City of Albuquerque Parks and Recreation Department

Development Review Board Comments

1002261

Montano Vista Subdivision and Estates at Taylor Ranch

**PLAT OF**  
**LOT 16-A, MONTANO VISTA SUBDIVISION**  
**& LOT 37-A, THE ESTATES AT TAYLOR RIDGE**  
 SITUATE WITHIN SECTION 25 & 26,  
 T. 11 N., R. 2 E., N.M.P.M.  
 CITY OF ALBUQUERQUE  
 BERNALILLO COUNTY, NEW MEXICO  
 AUGUST, 2002

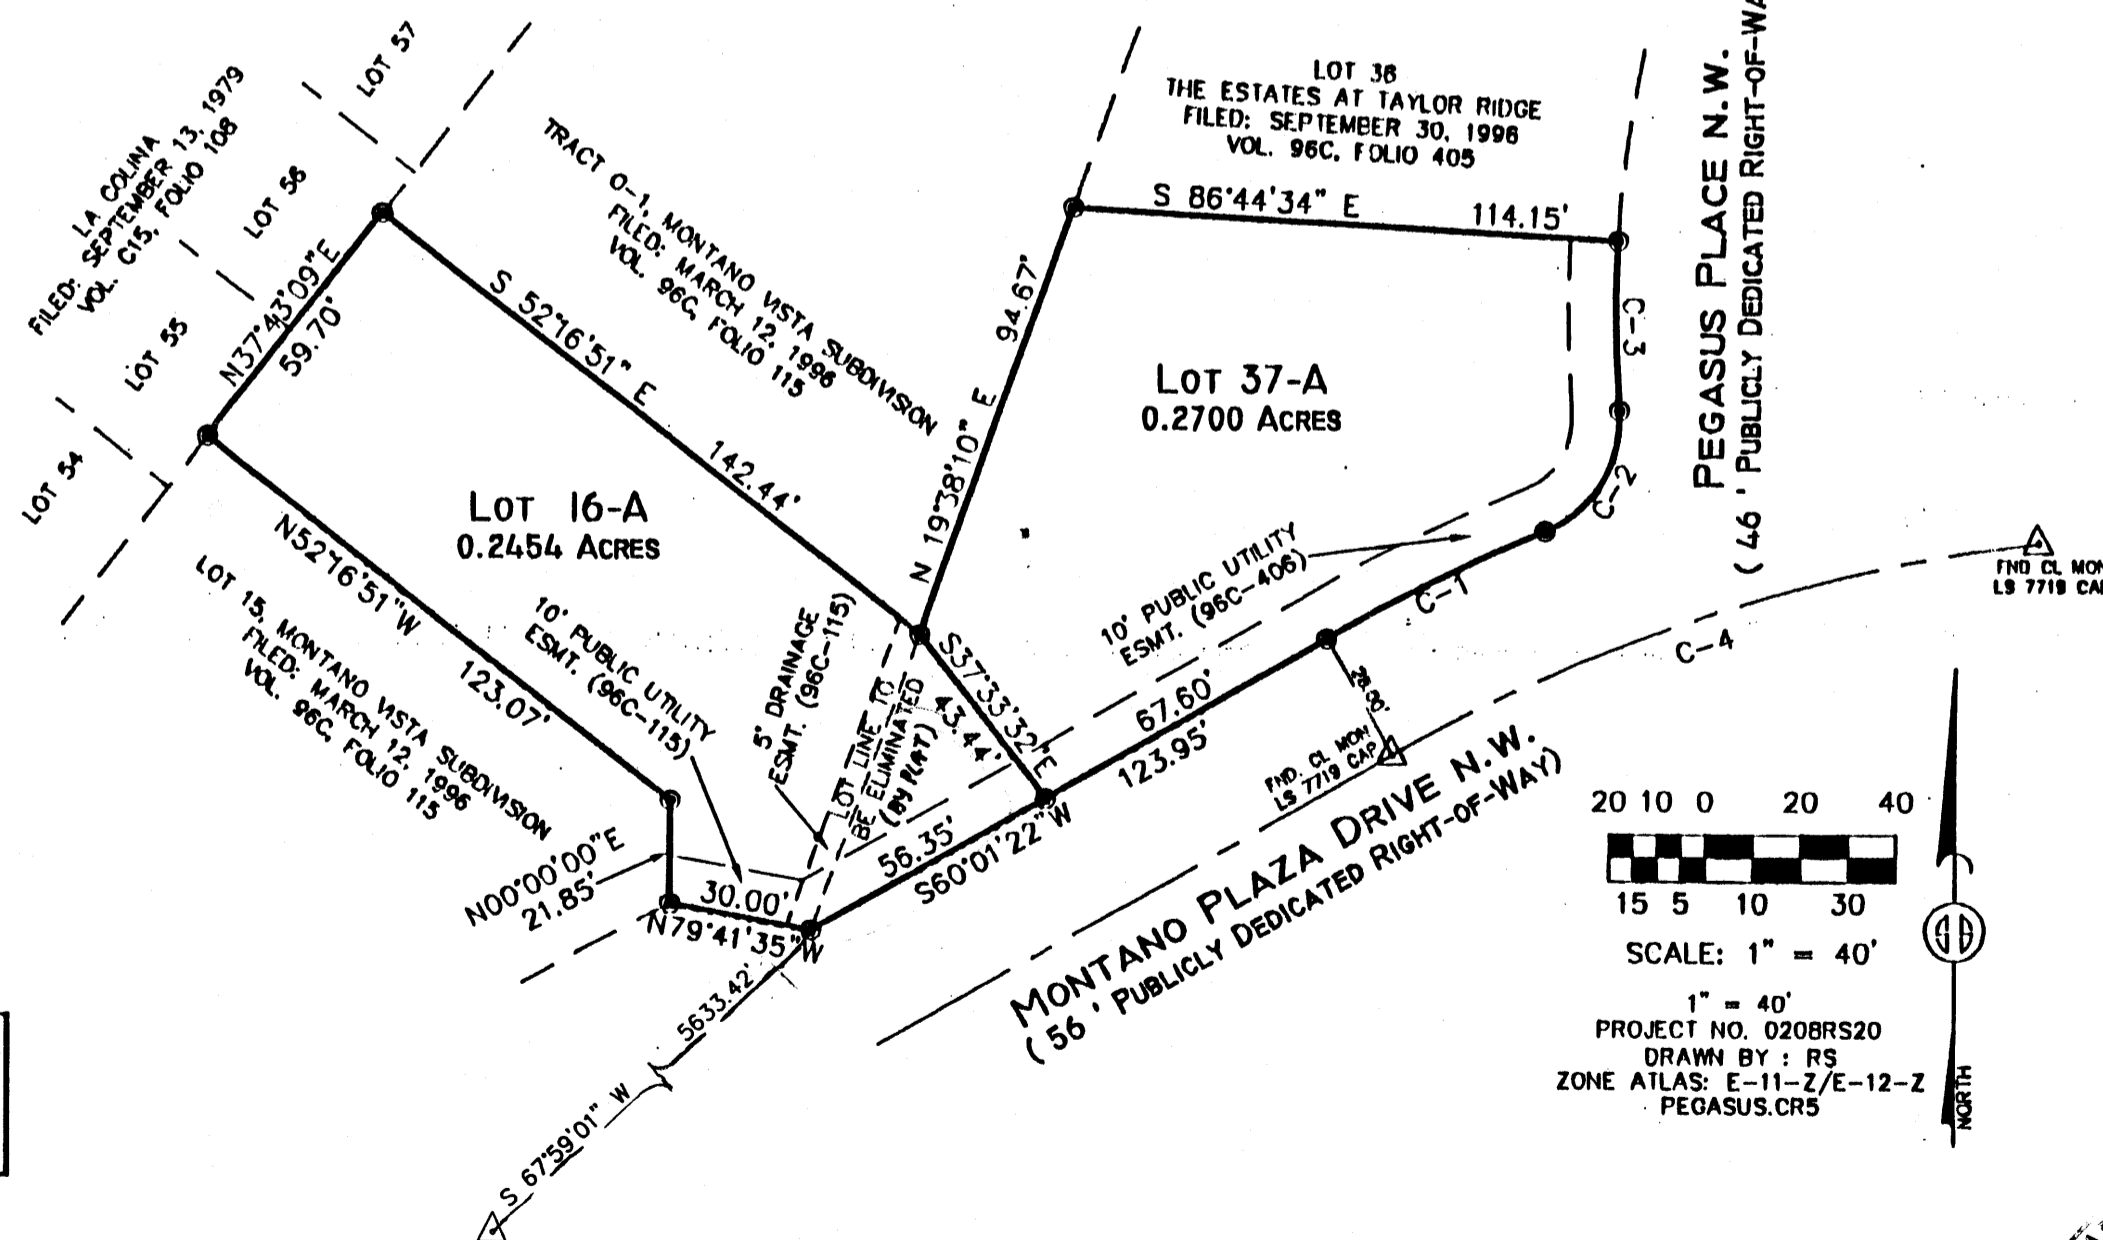
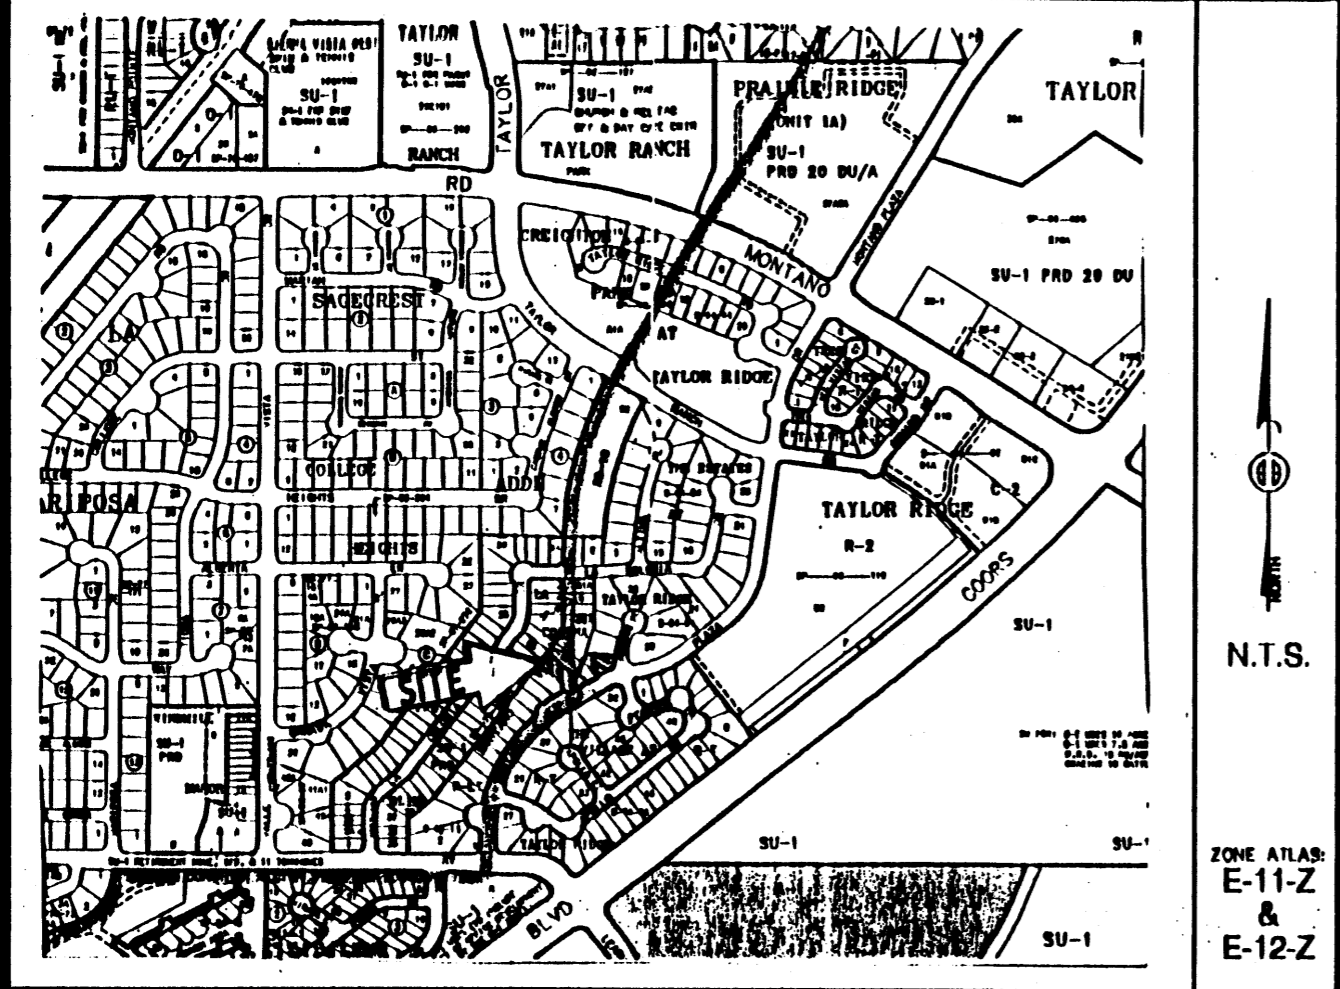
- 1. Refer to Note #9 under the Subdivision Data/Notes section of the plat. Lot 37-A is zoned R-1; however, Lot 16-A is zoned R-LT. Lots should be platted in accordance with the zoning.

- 2. What is the purpose of plat? According to aerial photographs from AGIS, there does not appear to be an encroachment that needs to be corrected.
- 3. Include the Project # and Application # on the plat.
